DRB Application No.: 08DRB-70213 Project # 1007275  
 Project Name: KW PHILLIPS ADDN, SLADE-OLSON  
 Agent: CARTESIAN SURVEYS INC Phone No.: 896-3050

### DEVELOPMENT REVIEW BOARD--SPEED MEMO

**DRB CASE NO/PROJECT NO: 1007275**

### DEVELOPMENT REVIEW BOARD MEMO

Plat of
Tracts A-1, B-1 and B-2
Slade-Olson Subdivision

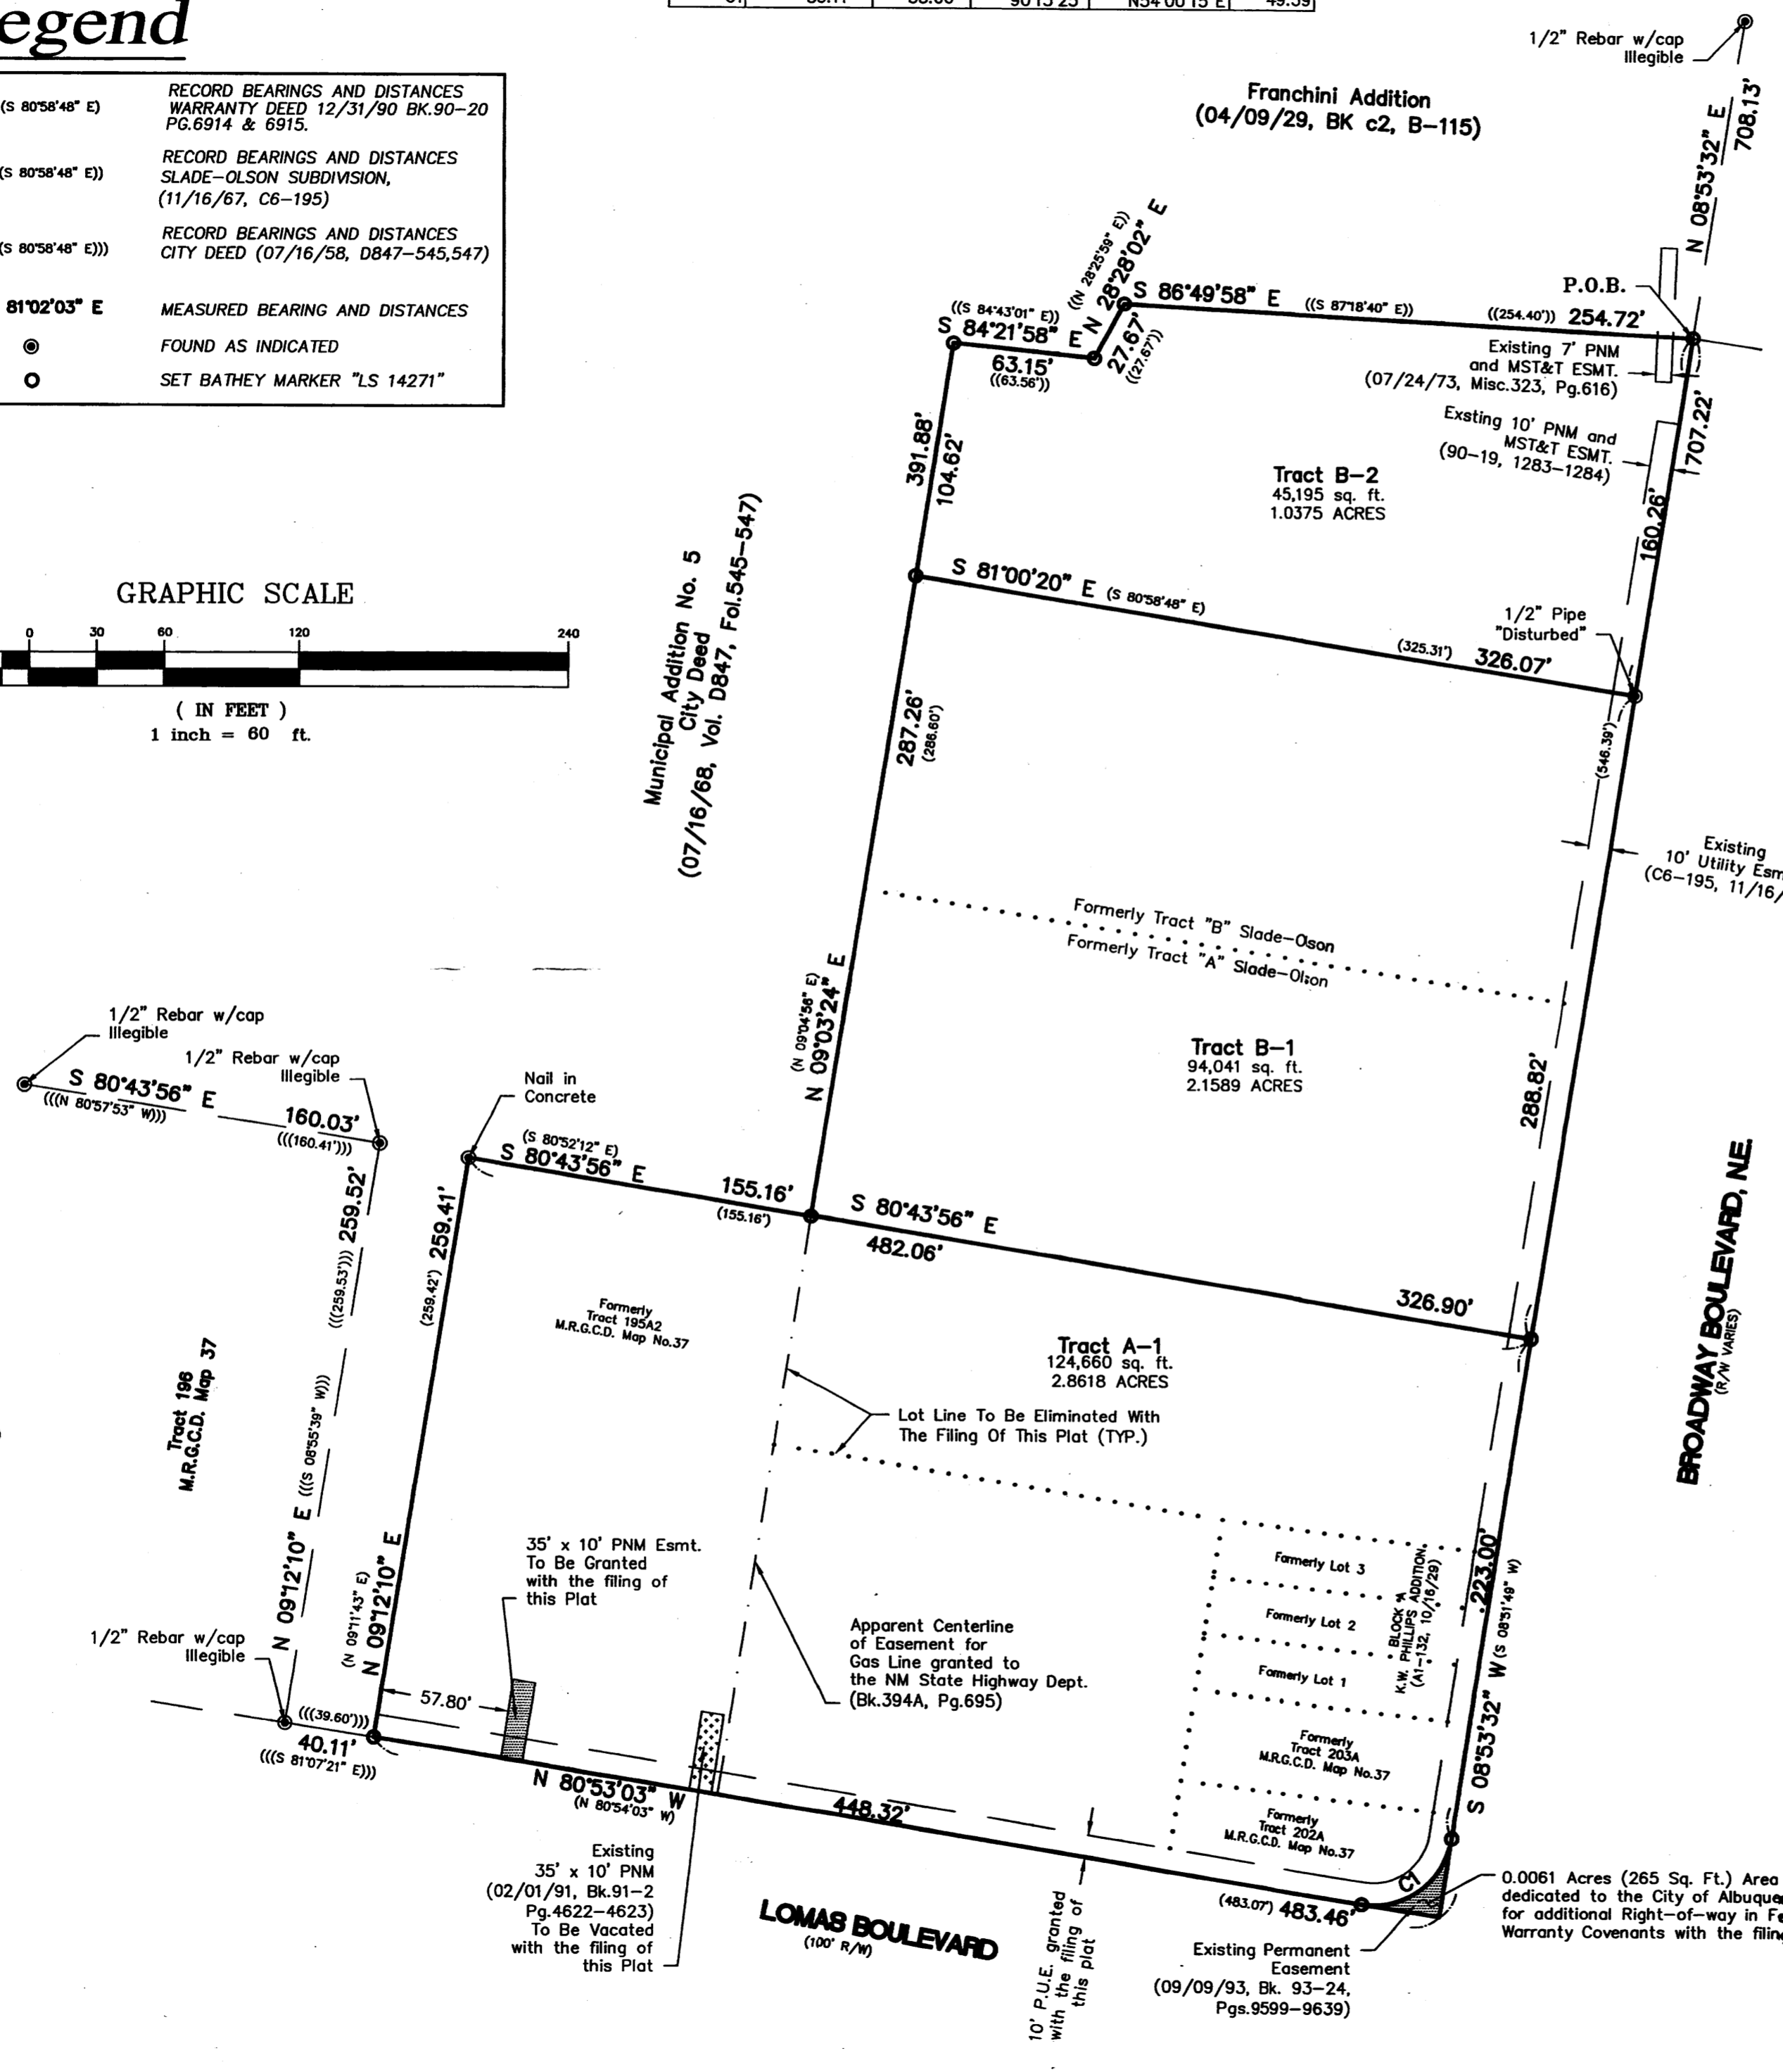
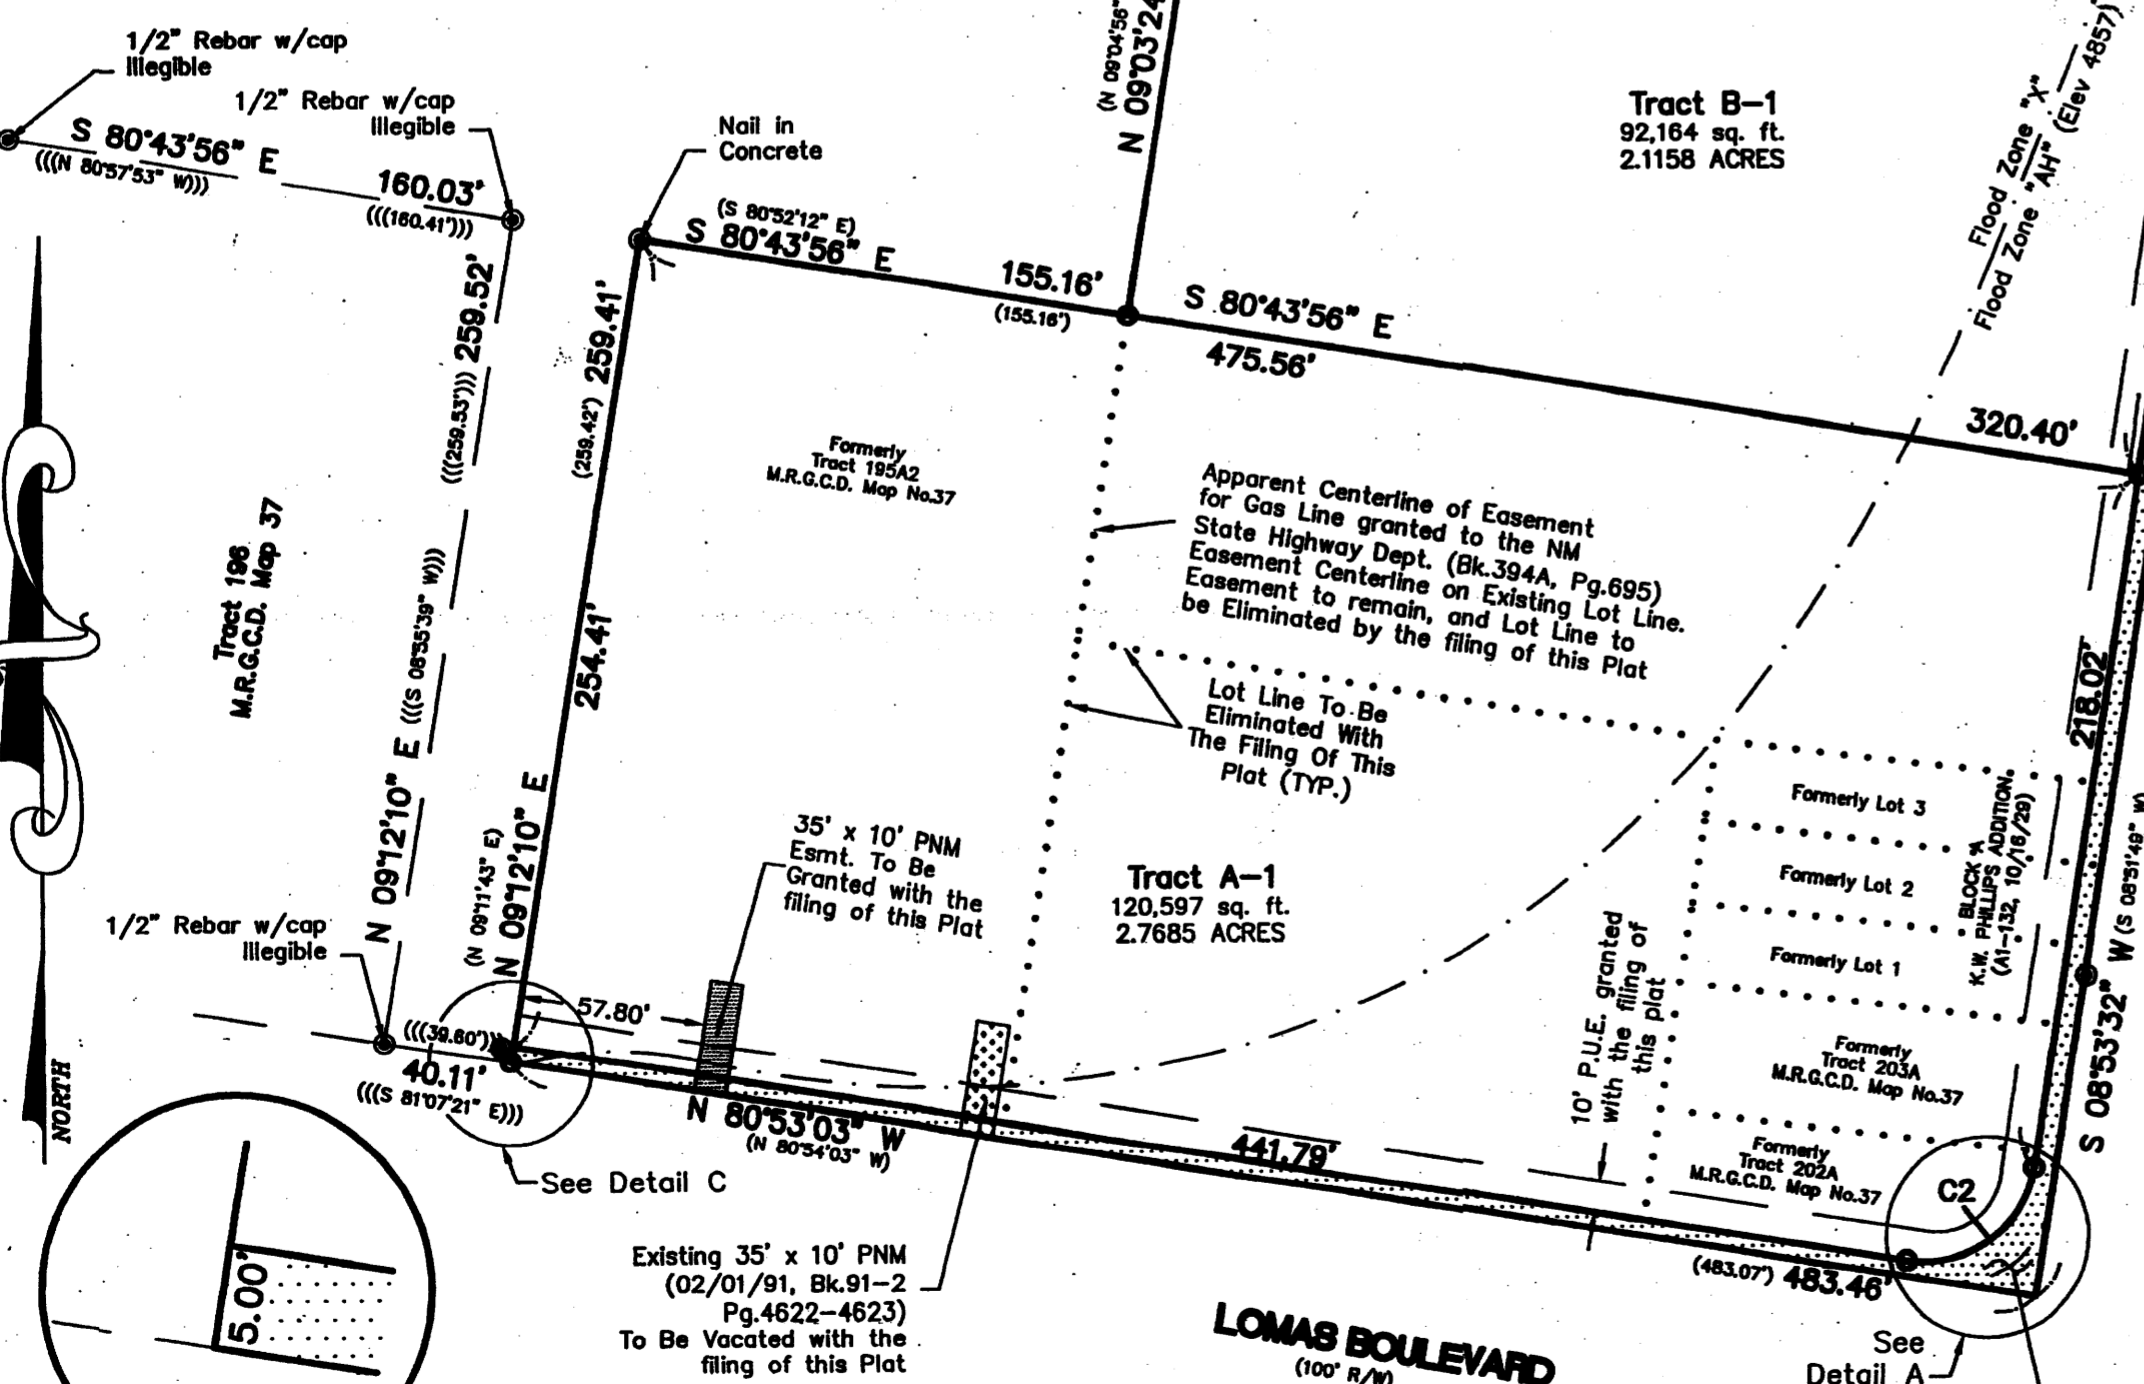
Shows limits of floodplain.

Requires a Conceptual Grading Plan and Drainage Report.  
Show the Floodplain on the Plat.
